PROJECT: Smith's #448
8301 Golf Course Road, NW
Albuquerque, NM 87120

RE: **Administrative Amendment, Accessibility Requirements comment**

Application reference: PR-2019-002643/ SI-2022-02251

SITE PLAN

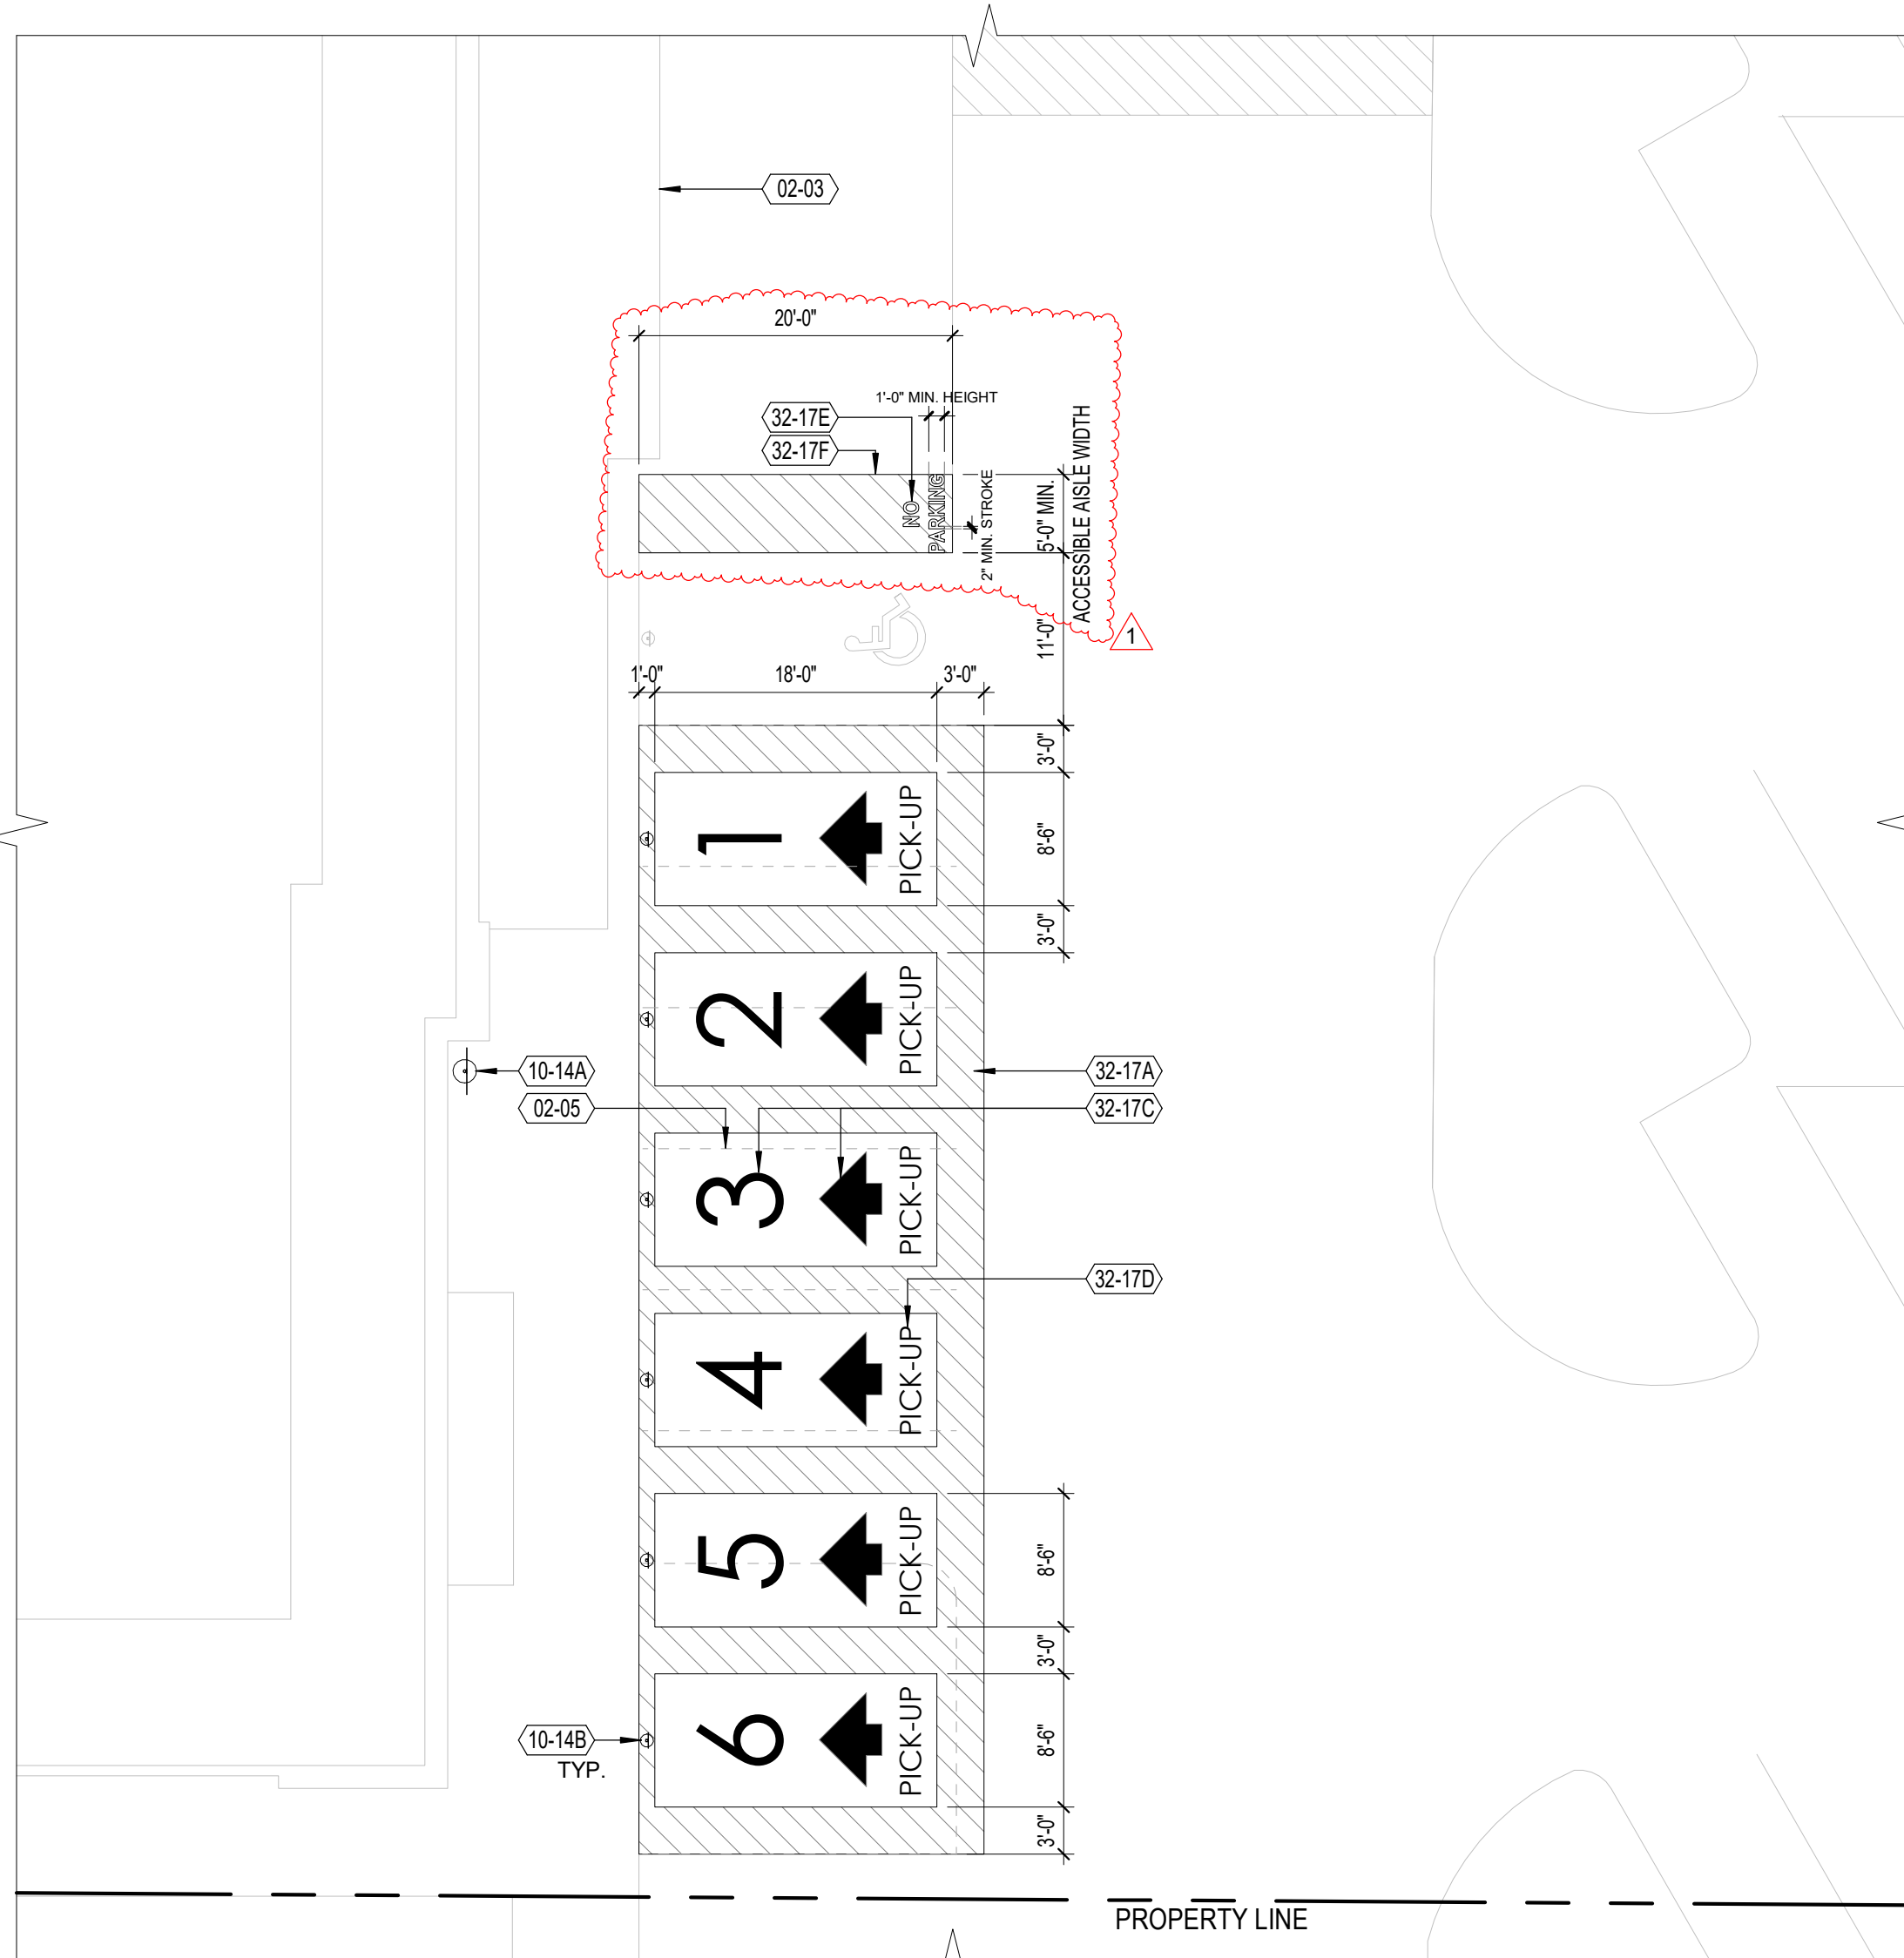
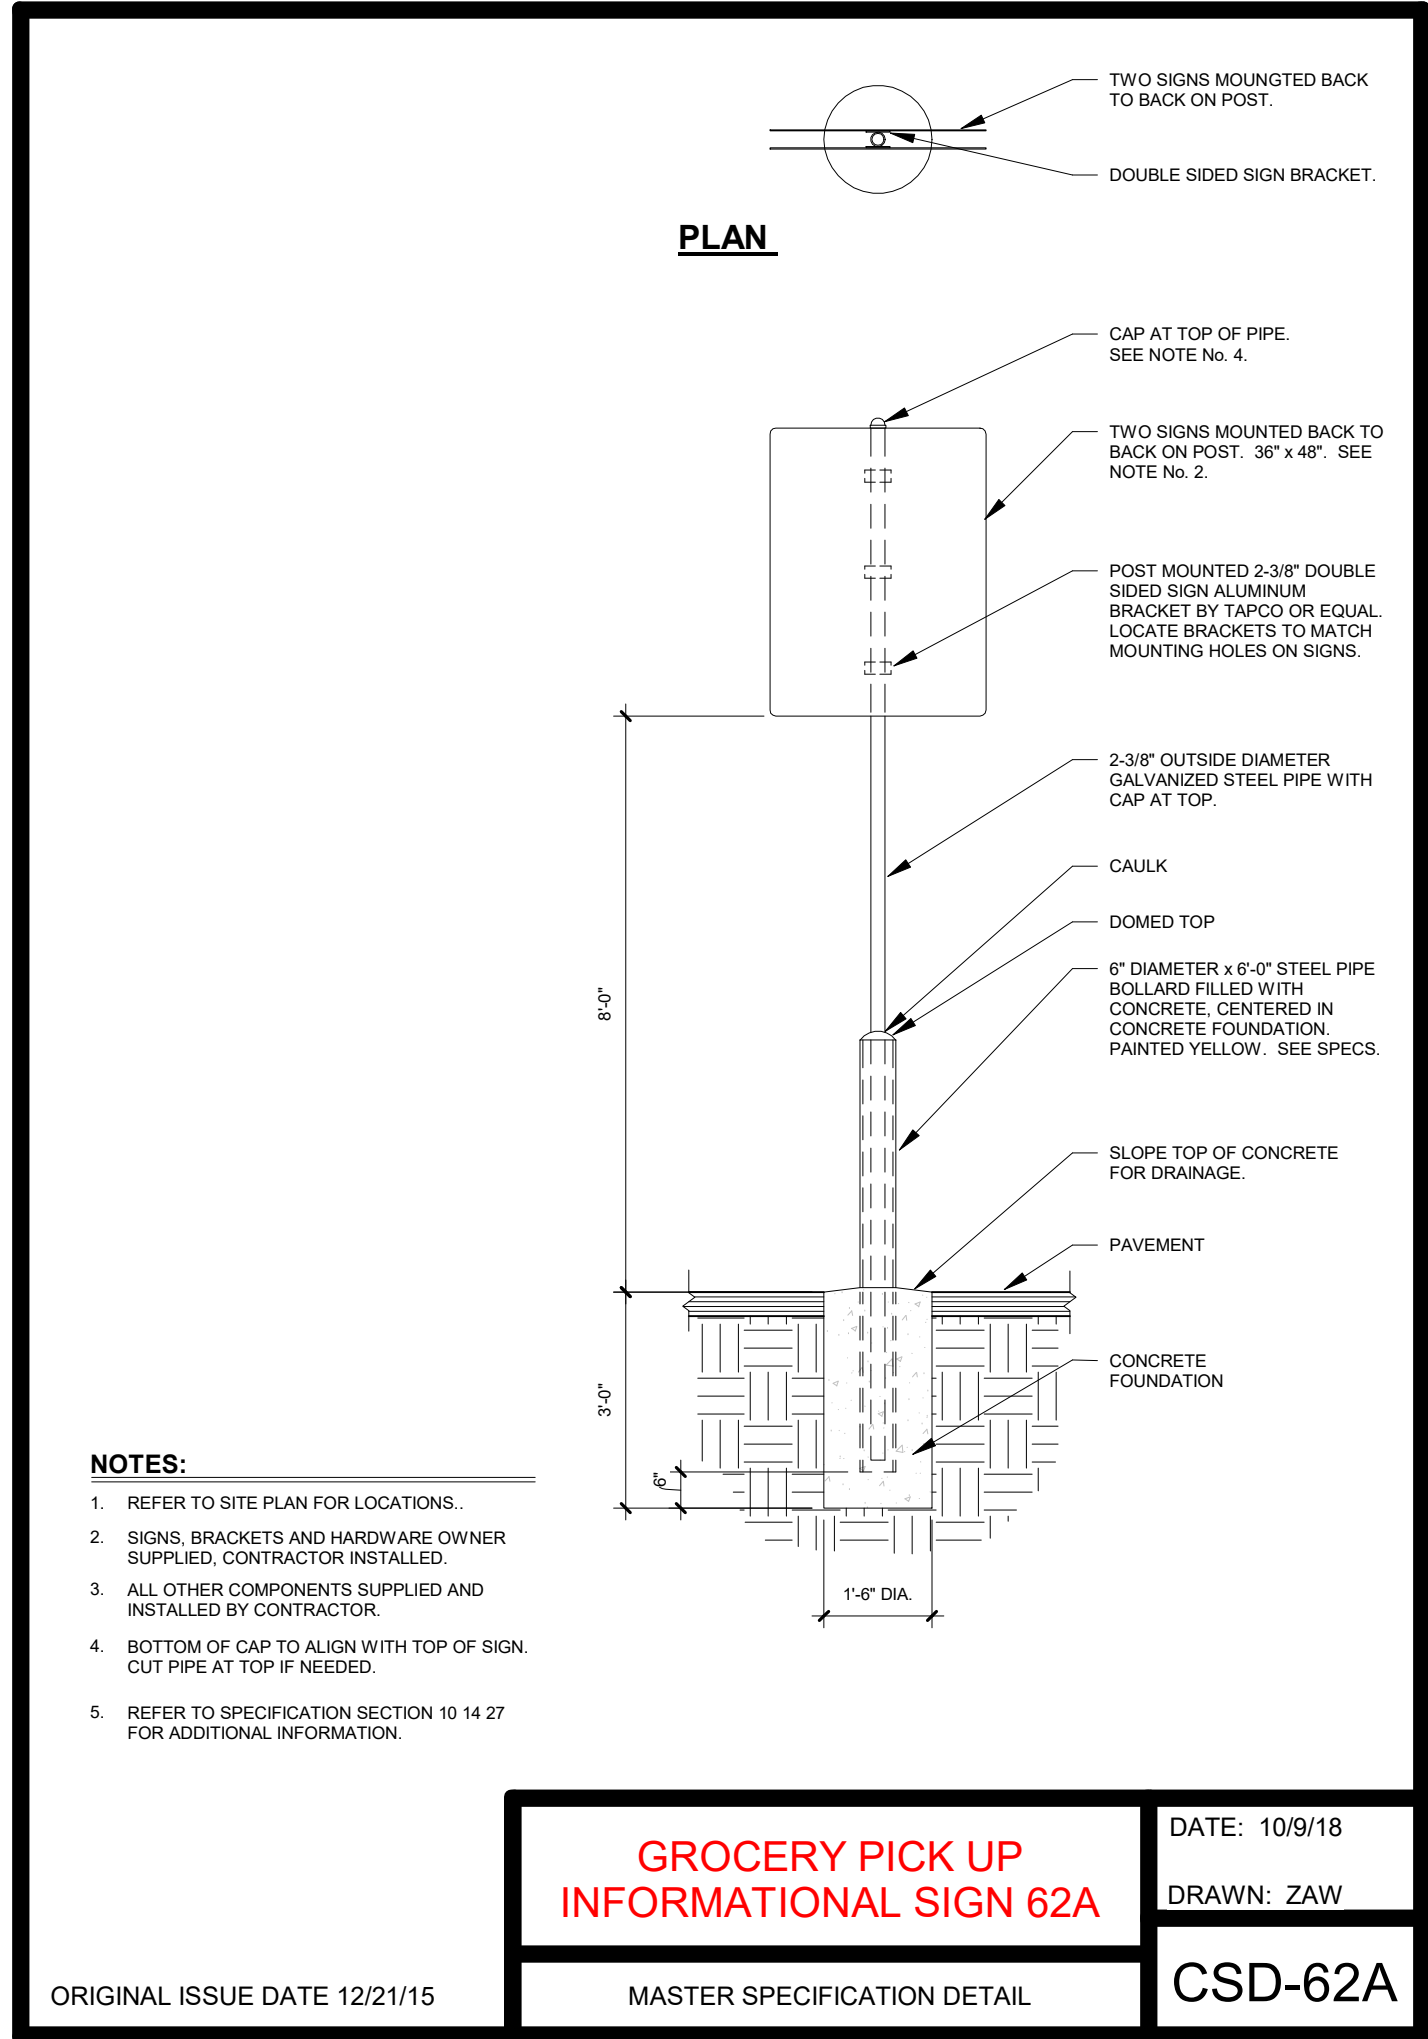
Good afternoon,
Please provide ADA access aisle (5 ft. wide) for the ADA parking space that adjacent to the proposed "PICK-UP" parking spaces. The ADA access aisles shall have the words "**NO PARKING**" in capital letters, each of which shall be at least one foot high and at least two inches wide, placed at the rear of the parking space so as to be close to where an adjacent vehicle's rear tire would be placed. (66-1-4.1.B NMSA 1978)

Mr. Marwa Al-najjar,
Please, see attached the memo with the Accessibility requirements indicated per your review and the associated revised sheets A0.1 and A0.2 with the required corrections, clouded and identified with a delta #1 and today's date.
Kind regards
